From: Tim Townsend [REDACTED]
Sent: 08 April 2022 14:04
To: [REDACTED]
Cc: [REDACTED] David Jukes [REDACTED] Simon Davis
<Simon.Davis@arun.gov.uk>; 'Nigel Jarvis' [REDACTED] Steven Shaw
[REDACTED]
Subject: RE: 2087 - Woodgate - Final comments and RSA sign off query.

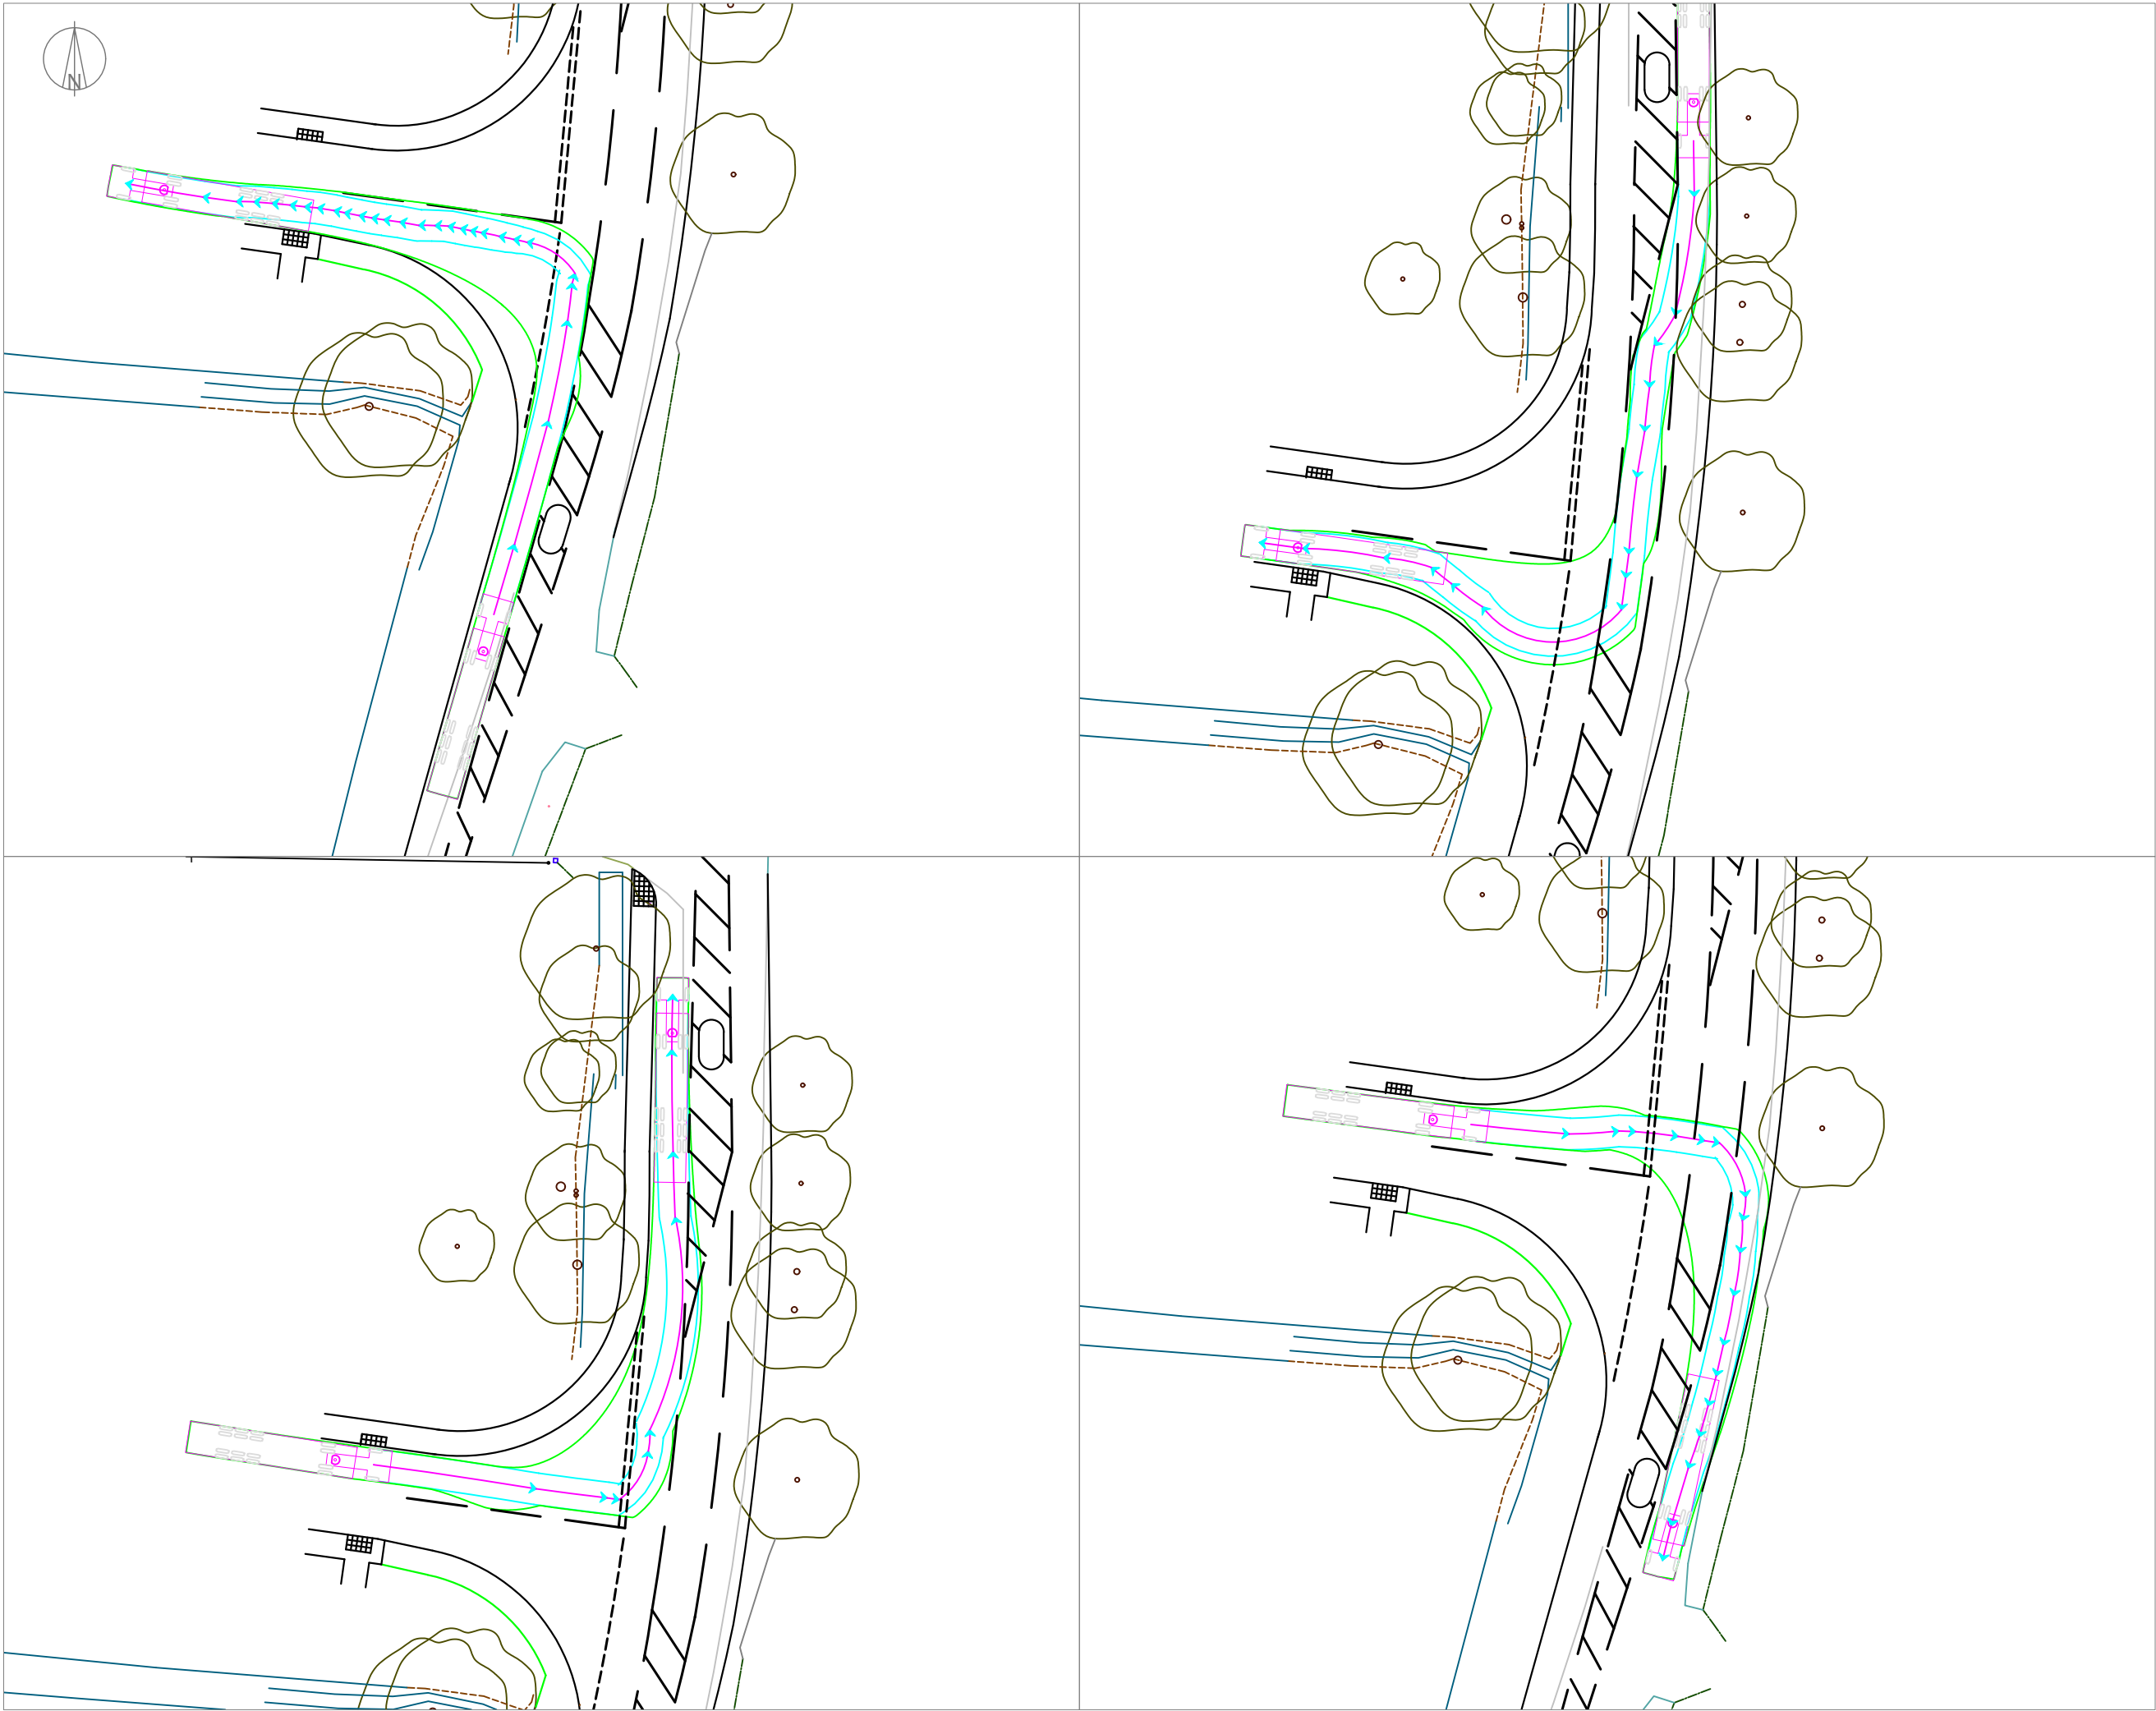
Having looked at the various details alongside DMRB, my view is that the design now demonstrates the appropriate kerb-to-kerb widths. These will be checked again at detailed design stage (S278) should planning permission be granted for the proposal. All I would add at this stage is that I have not been able to discuss this with David Jukes as he is unavailable today and I do need to know he is happy from the Road Safety Audit viewpoint.

Please find updated drawings attached with the traffic islands widened to 1.8 metres with carriageway widening to the east to maintain the 3.15 metre through lane widths and 4.0 metre kerb to kerb widths. Due to the dimensions that are already shown on Sheet 2 on the main viewports we have added a small insert of the length and width.
